**From:**  
**To:** [DCAdmin](#)  
**Subject:** Planning applications 2020/90710 and 2020/90711  
**Date:** 09 May 2020 11:01:09

Title: **SITE ARRANGEMENT & OVERALL SITE PLAN**

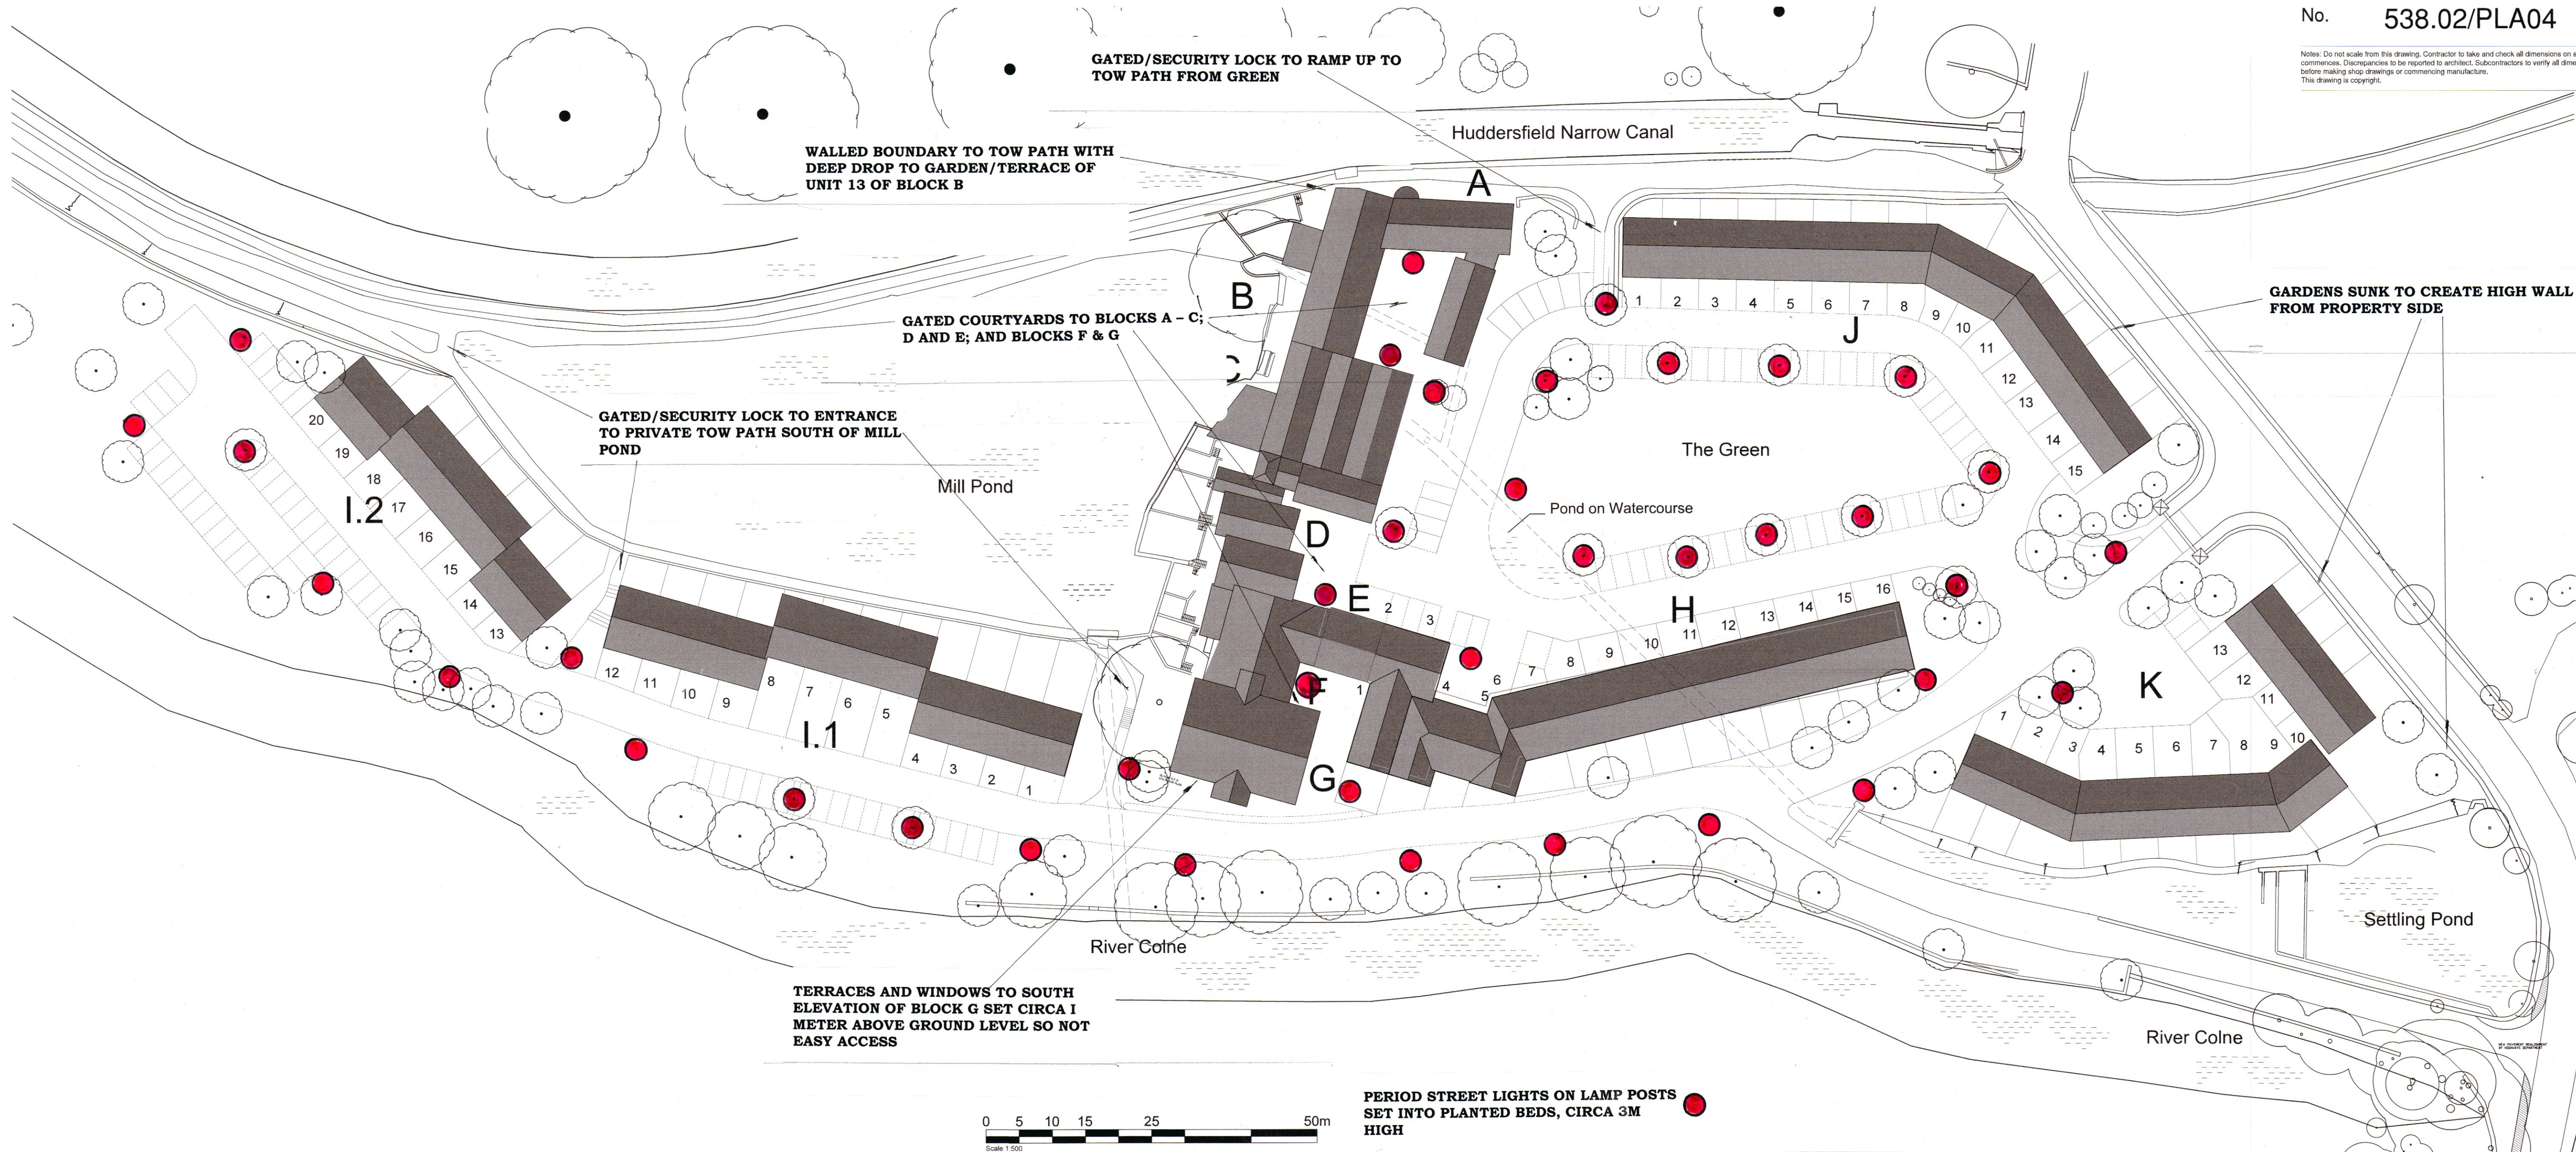
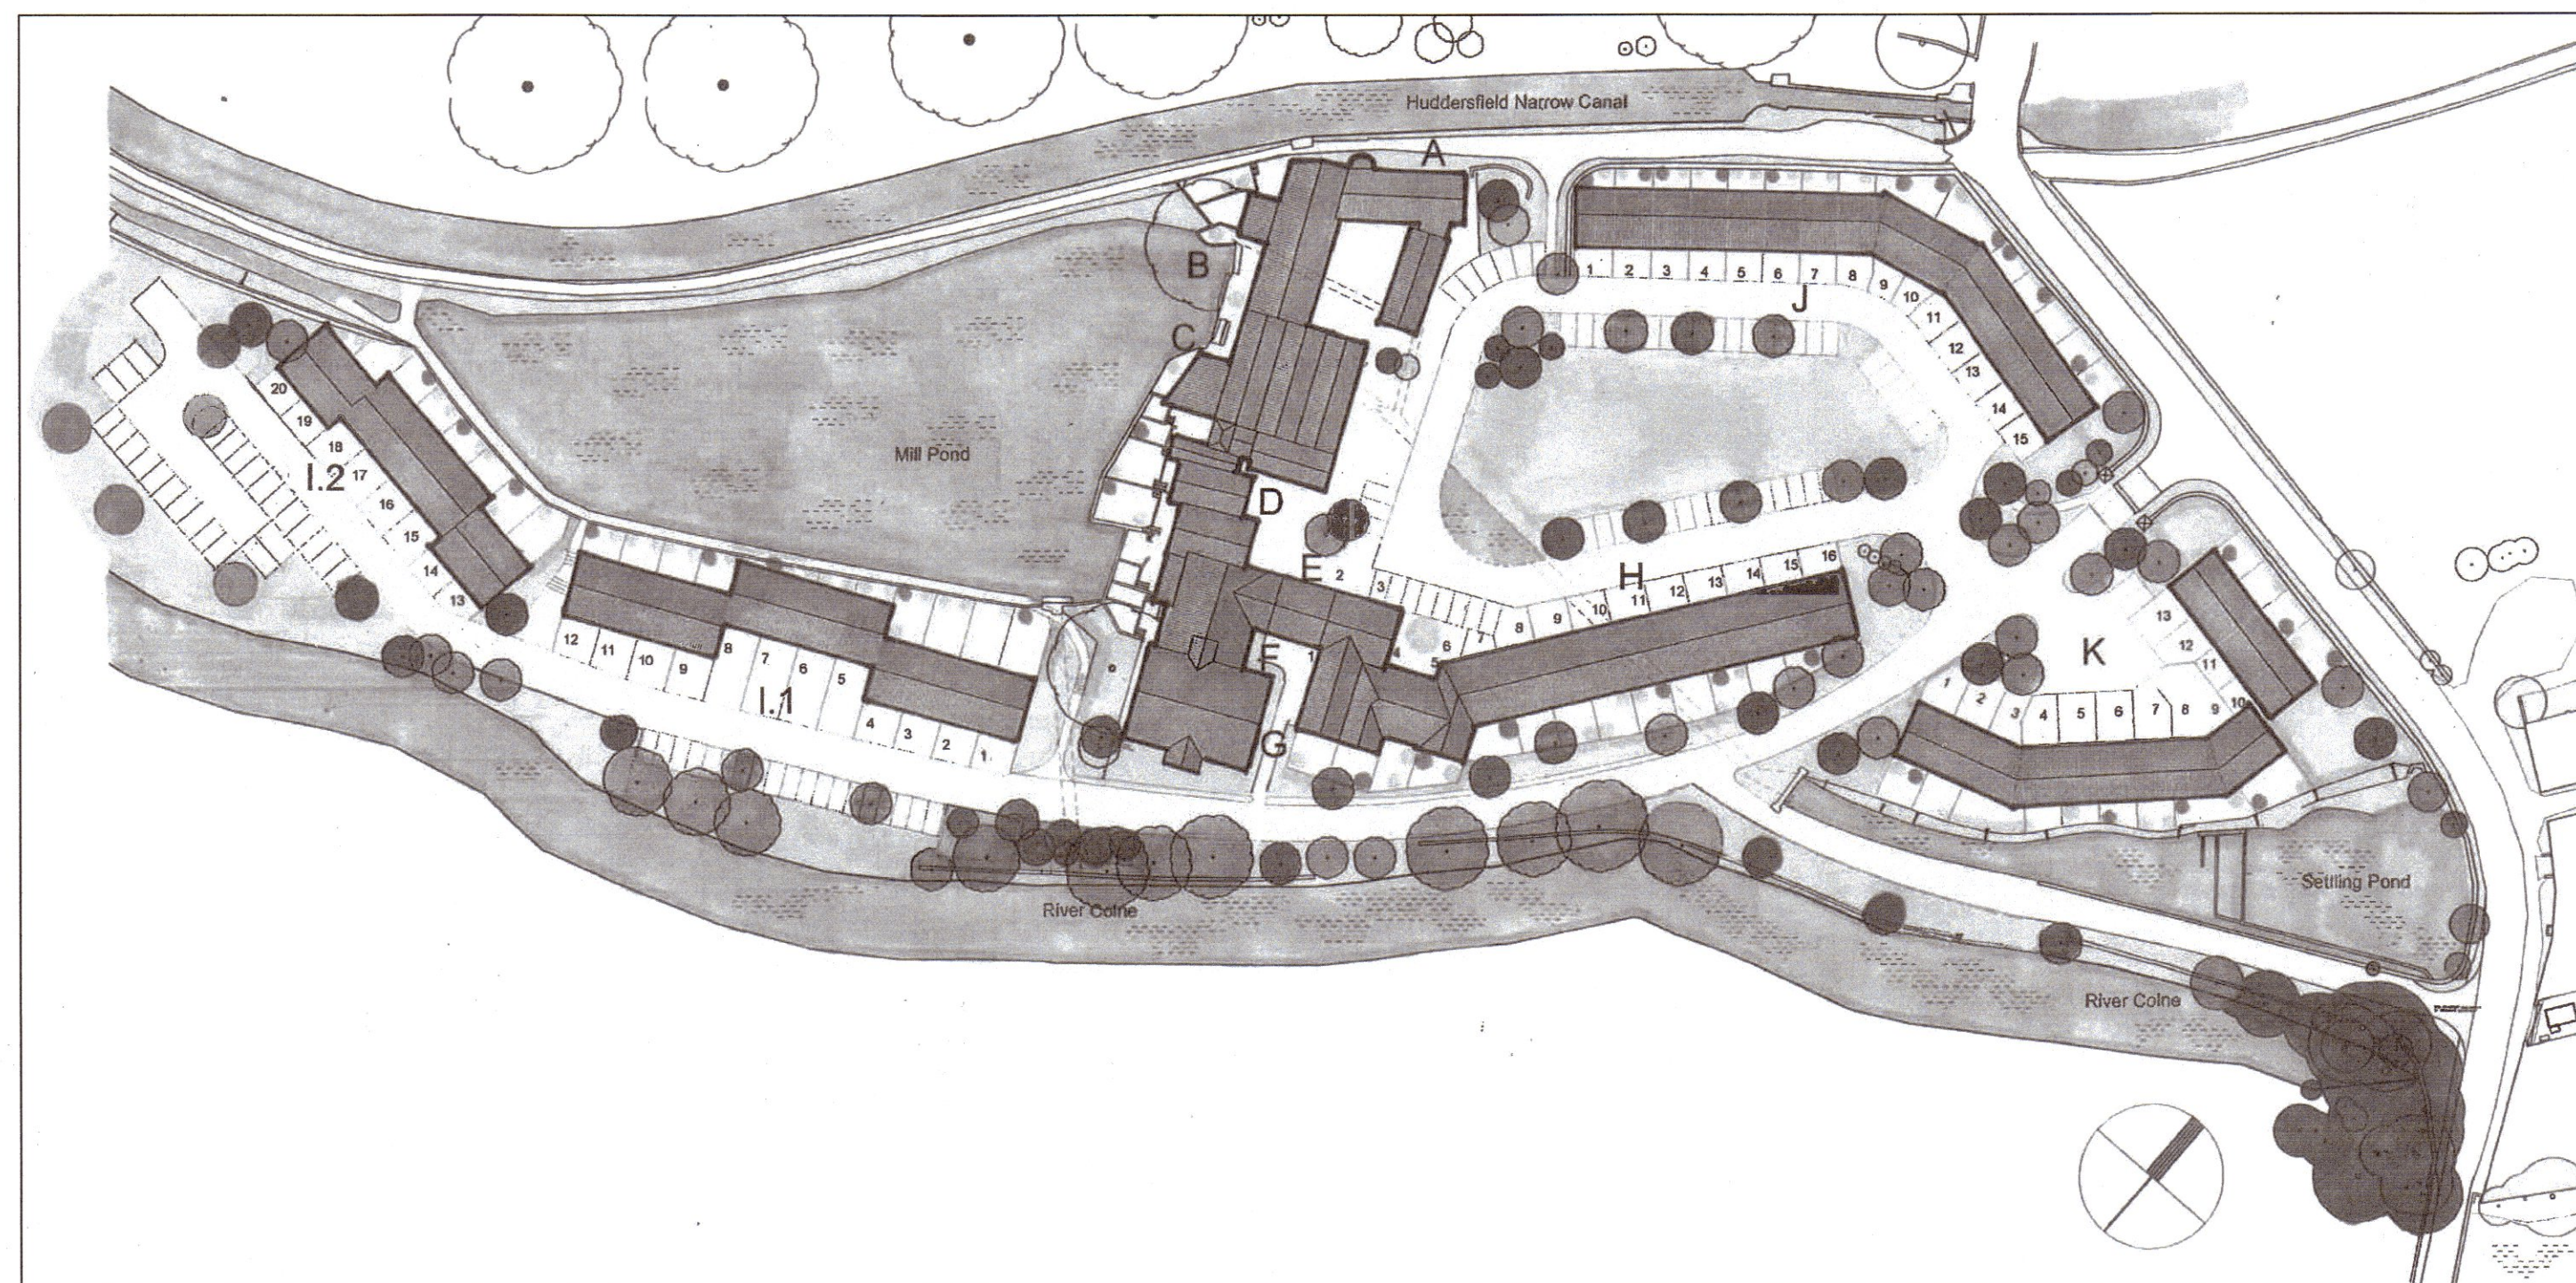
The Ramblers notes that the developers intend to dedicate a public right of way through the site from Low Westwood Lane to the canal towpath, and **enthusiastically approves of this move**. We ask in particular that the section of the right of way from Low Westwood Lane between the river and the settling pond be a path, for pedestrians only, with no vehicular access to the site. To minimise the effect of the development on users of this path, and to safeguard walkers, we also urge the developers to give consideration to routing this right of way along the river bank for as far as possible, all the way to the play zone if possible, to prevent walkers having to join the road through the development. Ideally the dedicated right of way would run closer to the river between the points marked X and Y on the plan below.
